Appeal Decision

Appeal Ref: APP/T2350/A/12/2189415

10 Market Place, Clitheroe, Lancashire BB7 2DA

Front elevation - scale 1:50 @ A0

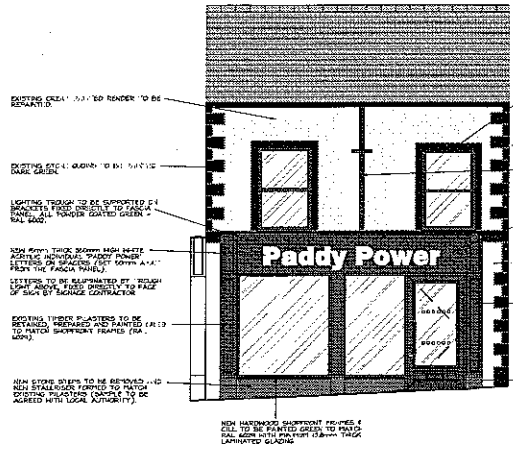
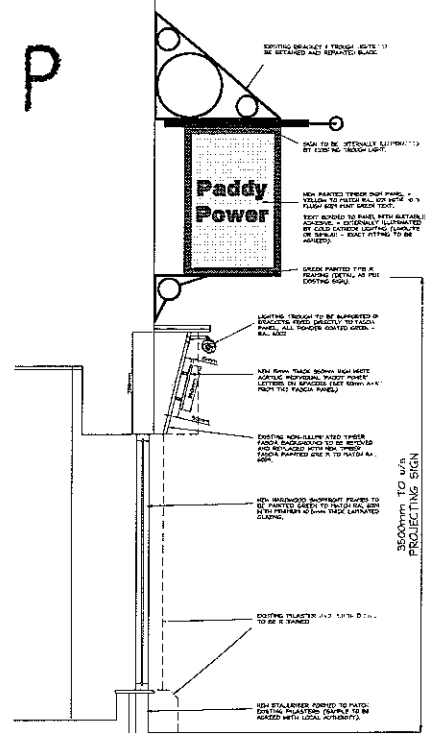
17. The Council does not take issue with all of the overall proposals for external alterations to the property, including installation of satellite dishes at the rear, and I see no reason to disagree. However, it objects to the proposed shop front and, in particular, the recessed entrance. The revised plans indicate a proposed shop front of similar overall dimensions to the existing, retaining the existing pilasters. The total area of shop window would exceed 50% of the width, albeit divided into two separate elements, and would retain an appropriate stall-riser. Hardly more than the width of the door itself would be recessed.

18. There are numerous examples, throughout the conservation area, including Market Place itself, of shopfronts, both modern and traditional, incorporating recessed elements. Although the *Clitheroe Conservation Area Appraisal* expresses concern regarding inappropriate modern materials or details on shopfronts, within the overall context, the scheme would represent an acceptable modern interpretation of traditional themes and would preserve the character and appearance of the conservation area. In addition, I am satisfied that the setting of the various listed buildings in Market place would also be preserved. It follows that there would be no conflict, in that respect, with LP Policies ENV16 or G1 or with the various paragraphs of the Framework and supporting guidance, relating to design and heritage, referred to by the Council, including paragraph 132, which requires great weight to be given to the conservation of designated heritage assets.
